Recommendation Report for Planning Permission for Works or Extension to a Dwelling

REF NO: BN/92/19/HH

LOCATION: Westray
3 Oriel Close
Barnham
PO22 0HN

PROPOSAL: Two storey side extension with new rear dormer and single storey rear extension, demolition of existing garage and new driveway with entrance gates.

19067-103^B

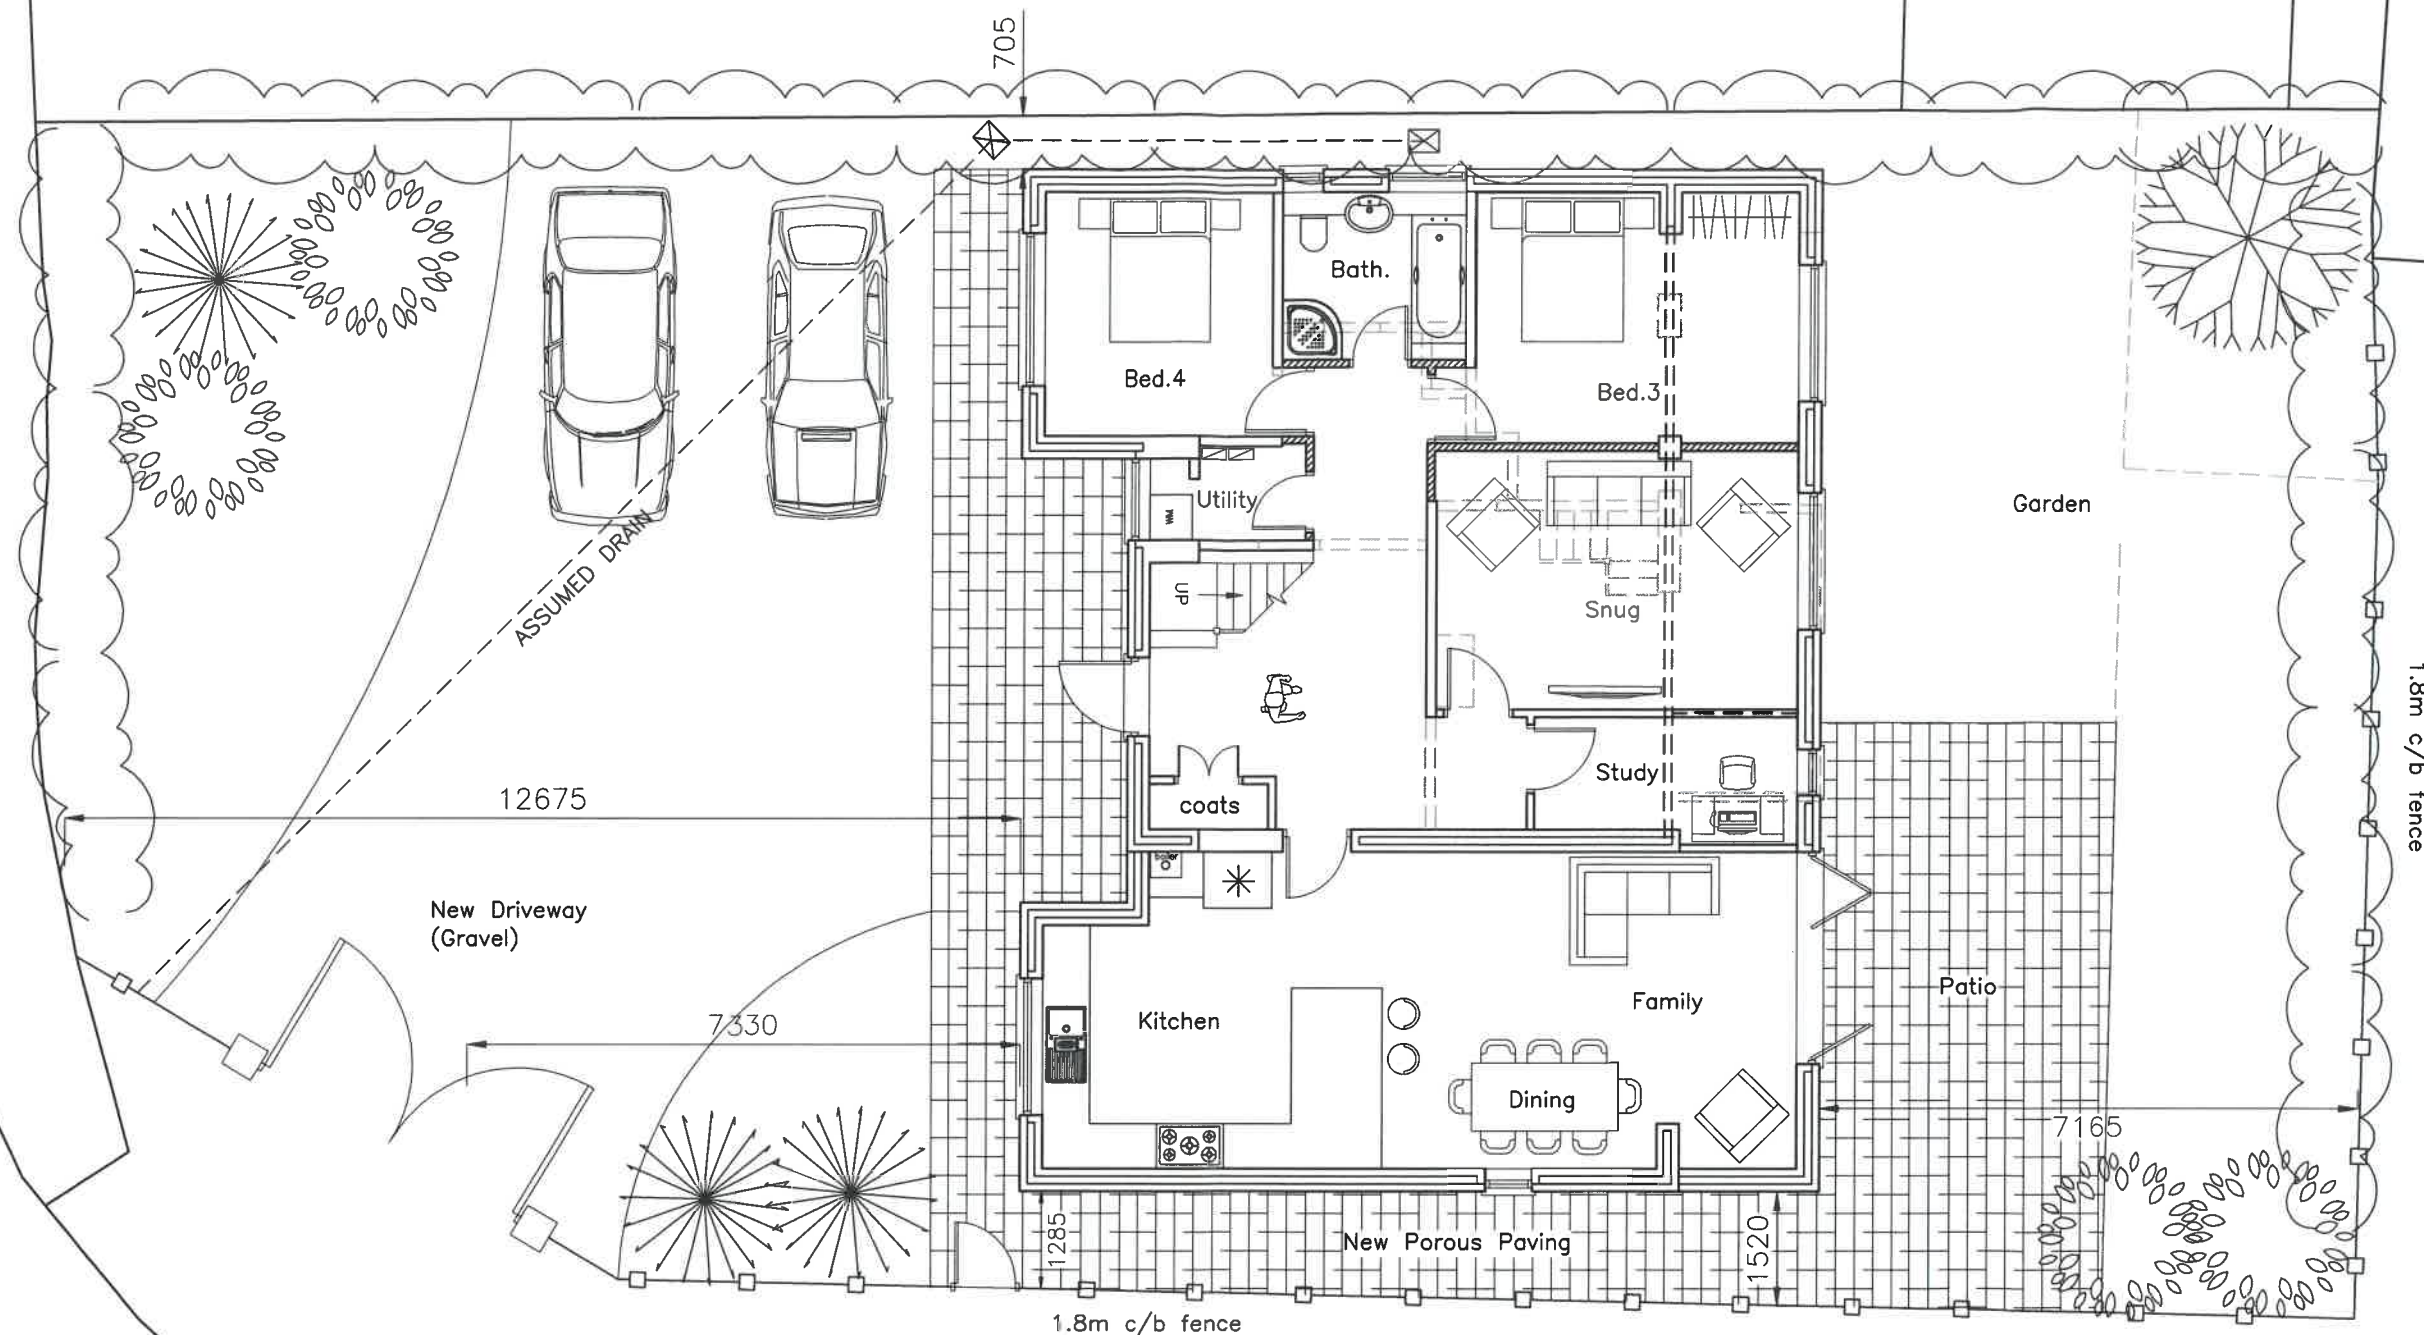
There is currently a 1m fence that runs along part of the front, side and rear of the property. This will be replaced with a fence of 1.8m height. There is however examples of fencing of this height at nearby properties at No.75 and No.73 and as such is not considered to appear out of character.

19067-501 ^A

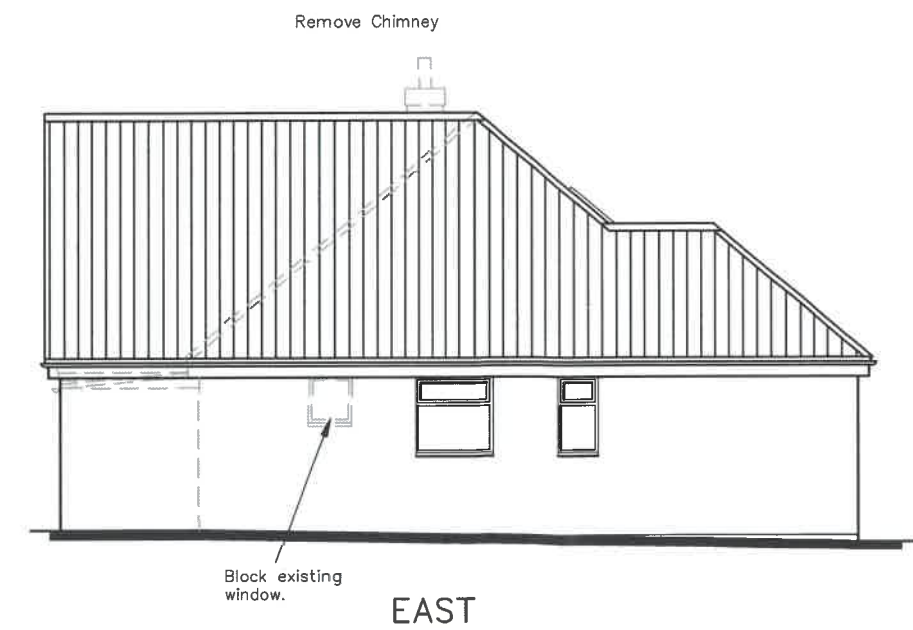
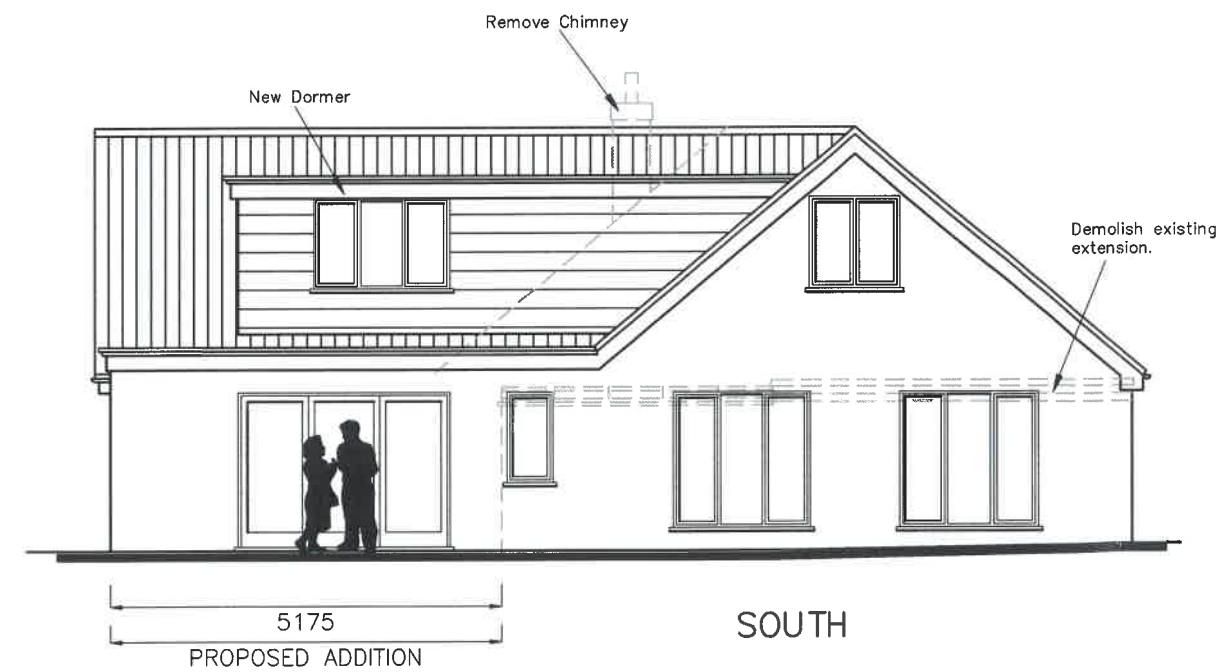
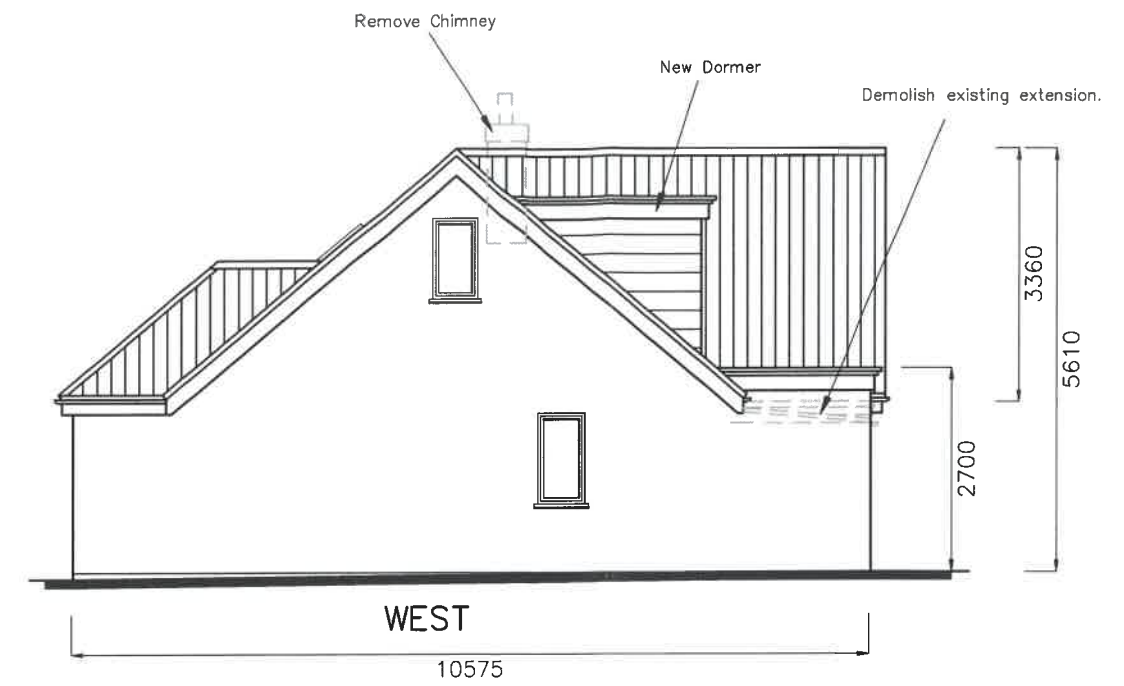
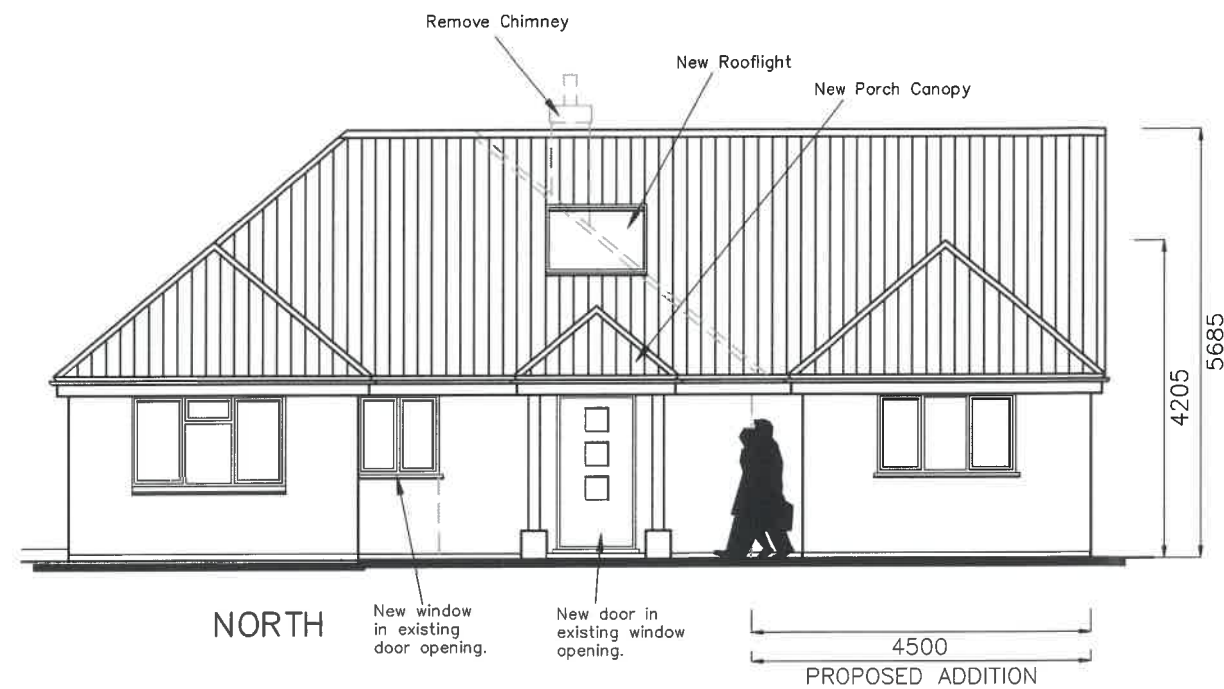
The property is an existing hipped roof chalet bungalow. The extension will be situated to the western side and run the full depth of the property with a gable end. There will be a small hipped addition to the front also, which matches that already in existence to the east.

The development appears well integrated and subservient to the host dwelling with materials to match existing. The dormer will be cladded however with this to the rear of the property and is not readily visible from the street scene.

The extension will be sited to the western elevation and will have a width of approximately 5.1m and a depth of 10.5 to meet with the existing rear. There is an existing rear conservatory however this will be removed and replaced with a gable roof extension to the eastern elevation with a width of 7m.. Whilst this increases in height to match that of the host dwelling, the depth will remain as existing at a maximum of 2m.

There will be a dormer to the rear elevation. This will have a height of 2m and a depth of 2.5m. It will extend across the full roof slope retaining approximately 1.8m to the western gable end. There is one window to the dormer and another to the gable end of the extension serving bedrooms, however due to the siting of these, it is not considered to give rise to adverse overlooking with views likely of the front

19067-402

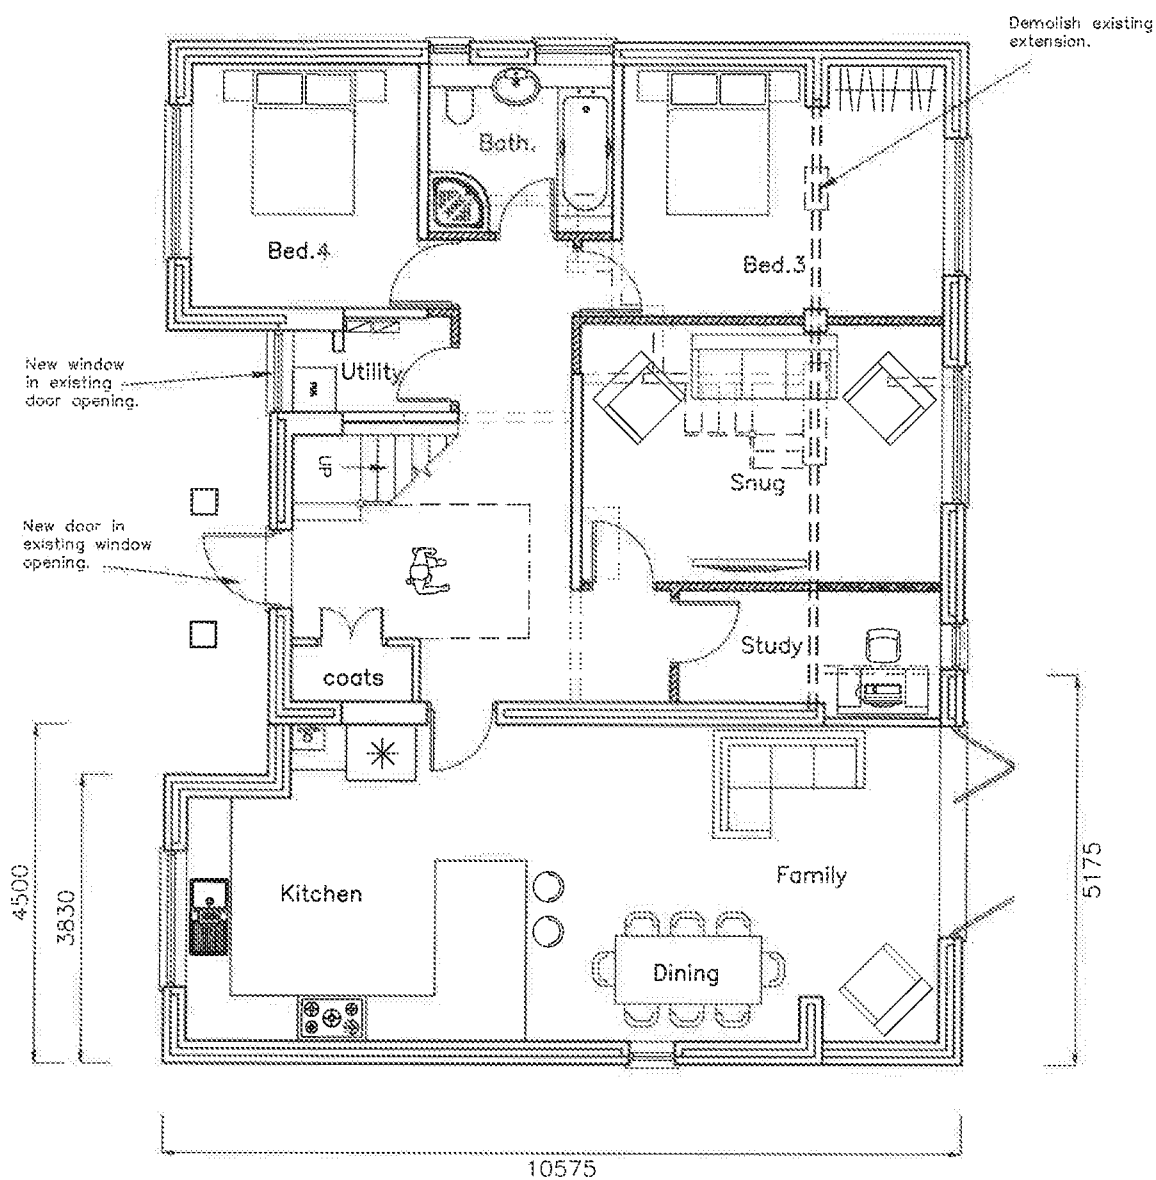
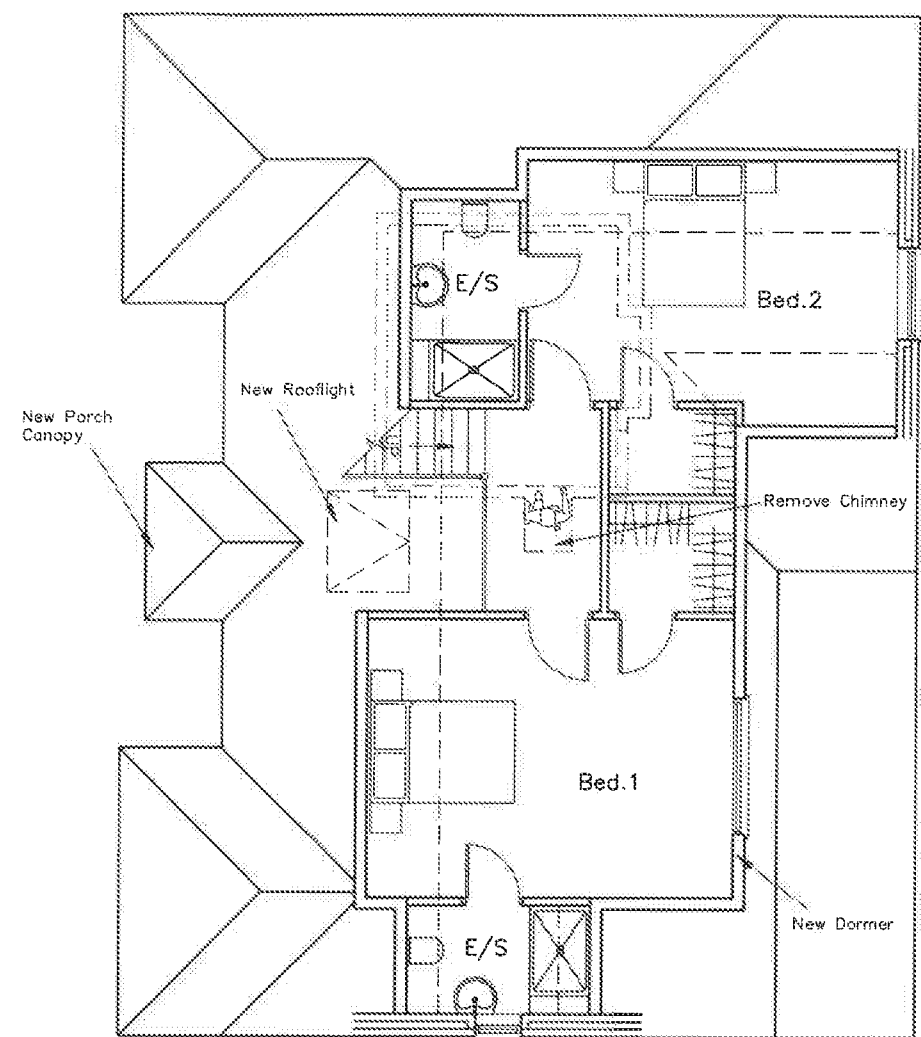
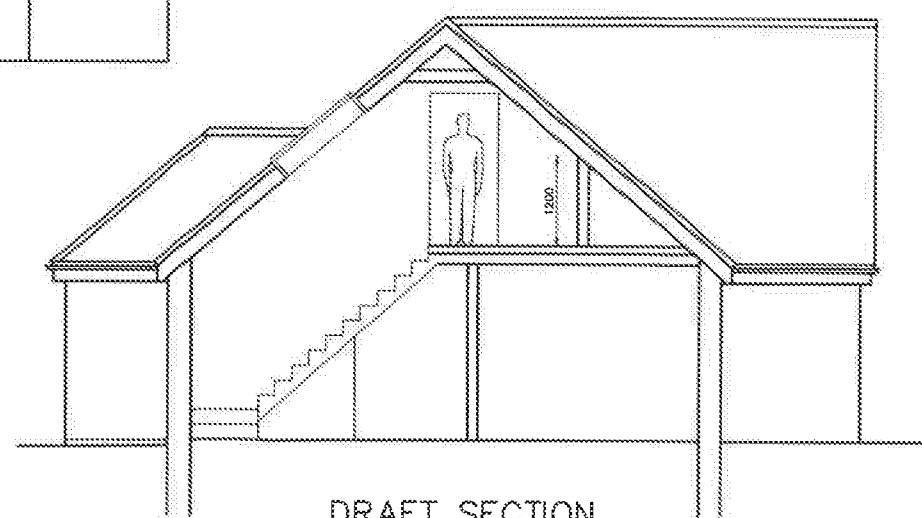
The extension to the west retains 1.5m to the boundary and with the road to this elevation, it is not deemed to appear adversely overbearing.
